Our Ref: K/22/09/

Construction of third floor extension with flat roof, first floor balcony access to sun deck, garage extension, additional driveway parking & boundary wall erected to front of property

Chelsfield 53 Coastal Road East Preston

Kingston Parish Council has the following objections and comments on the development proposed in planning application K/22/09: ☐

Notes

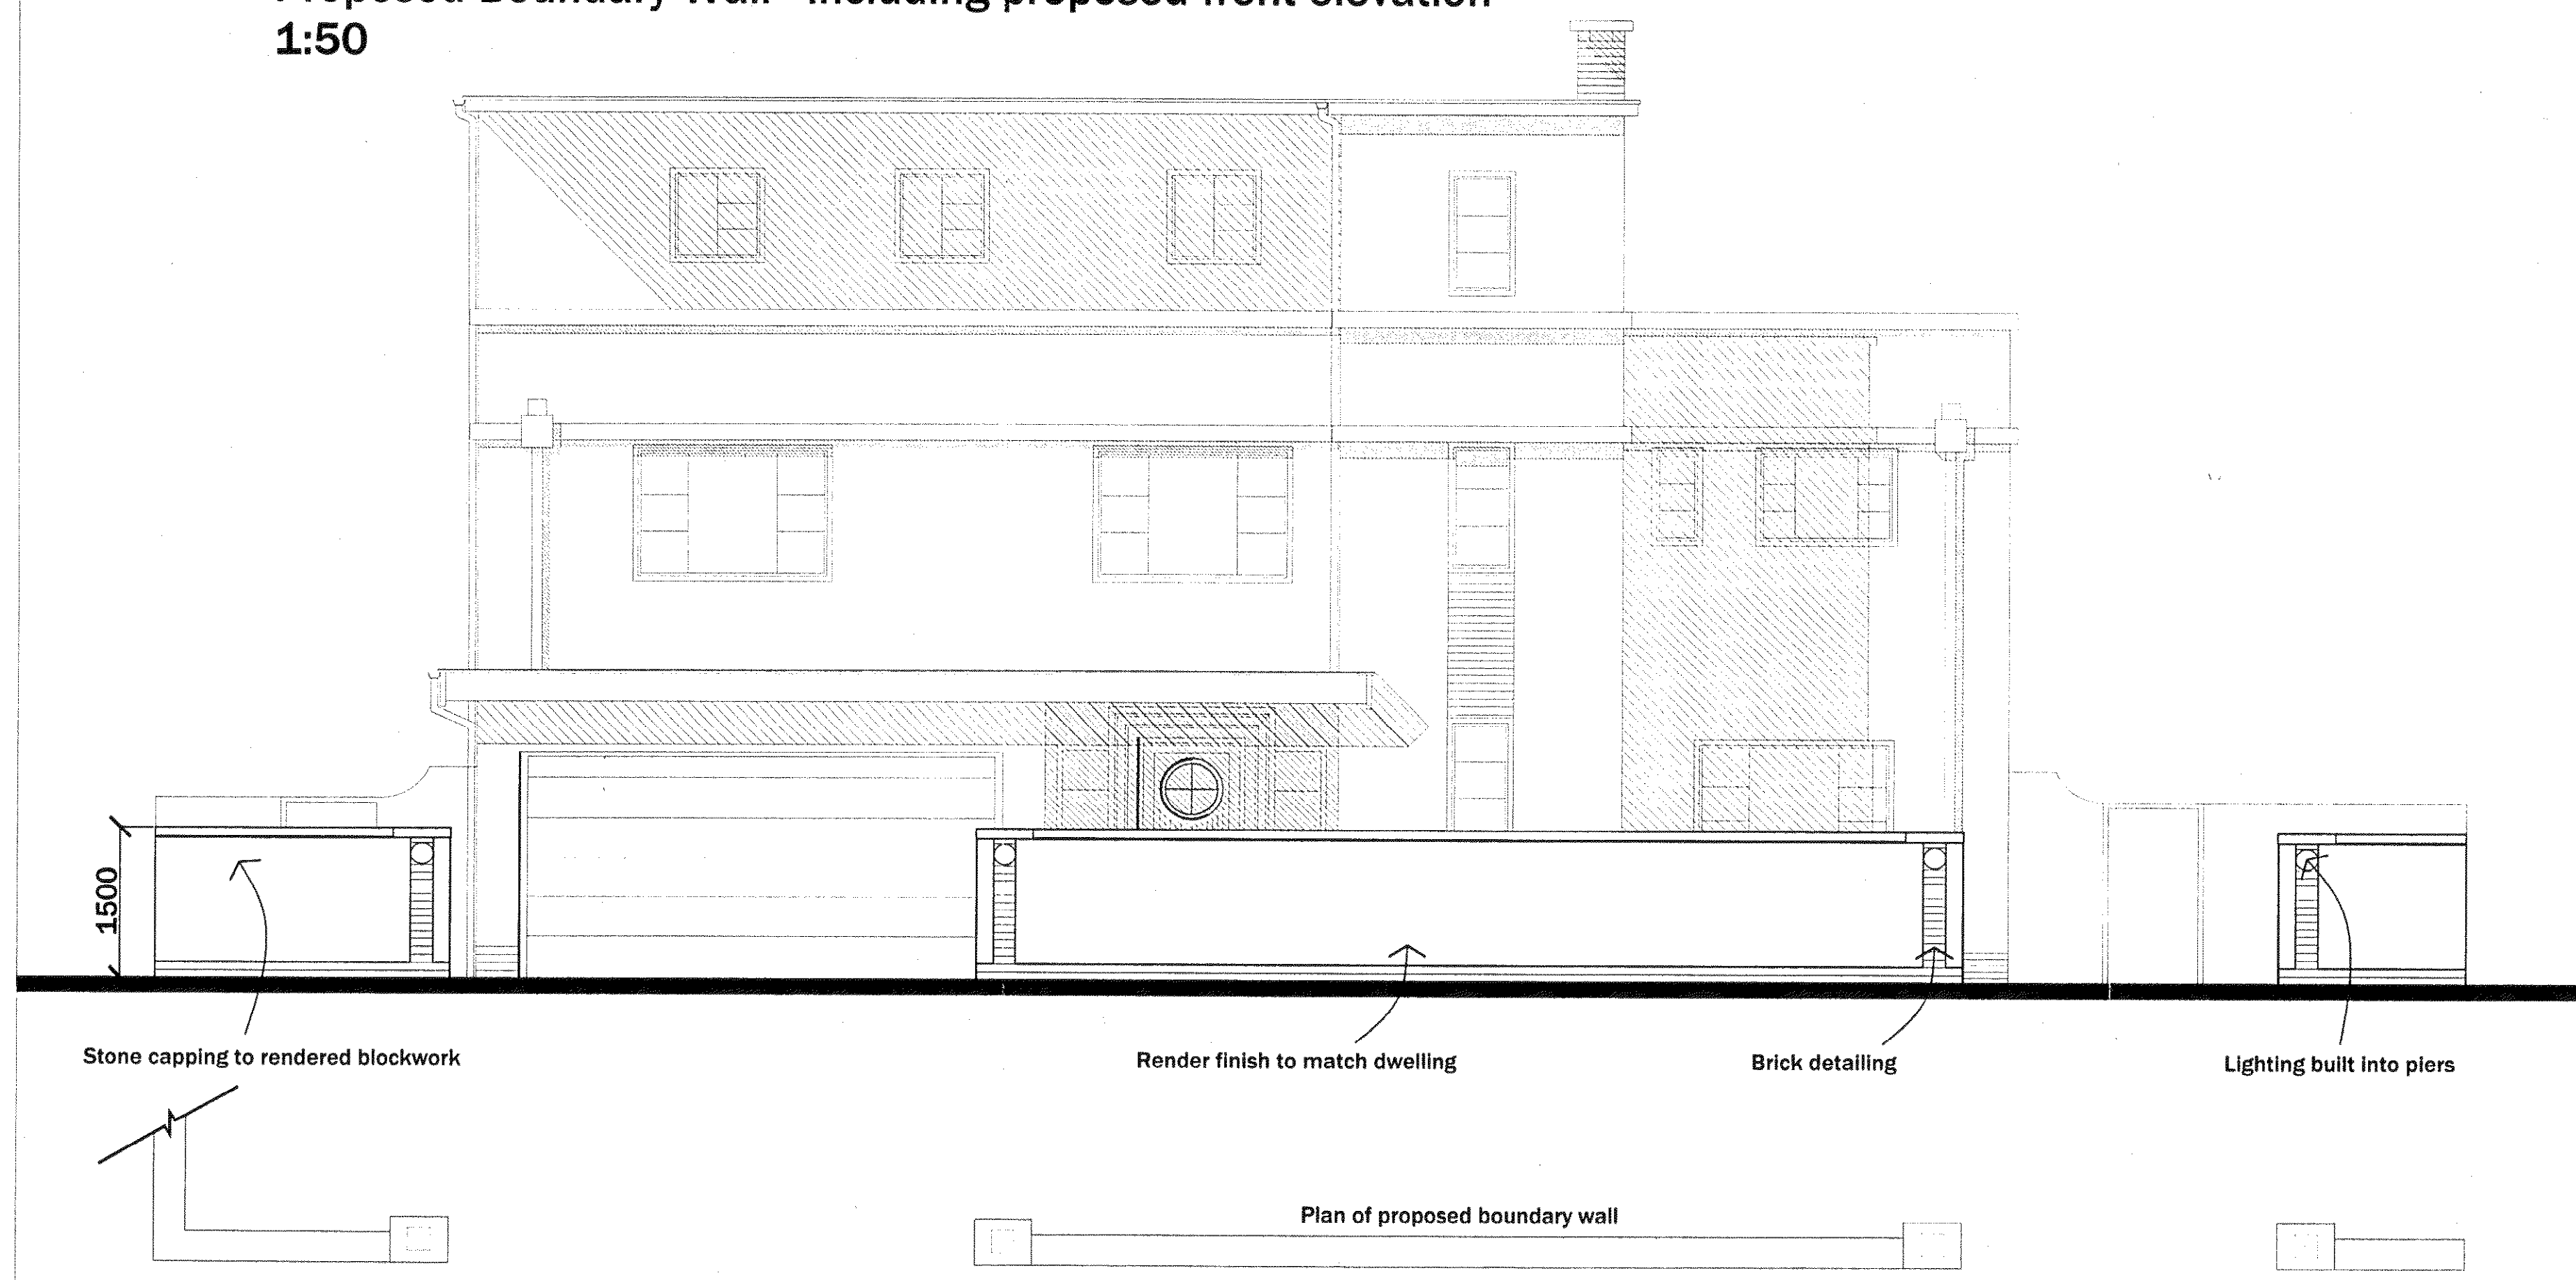
3. The erection of a high boundary wall to the front of property will have a detrimental effect on the street scene being a complete reversal to the existing open aspect of the frontage. ☐

4. Additionally re the proposed front boundary wall, there is a concern that this will create a hazard for pedestrians and motorists as there is insufficient visibility splay and sight line when vehicles are exiting the property. ☐
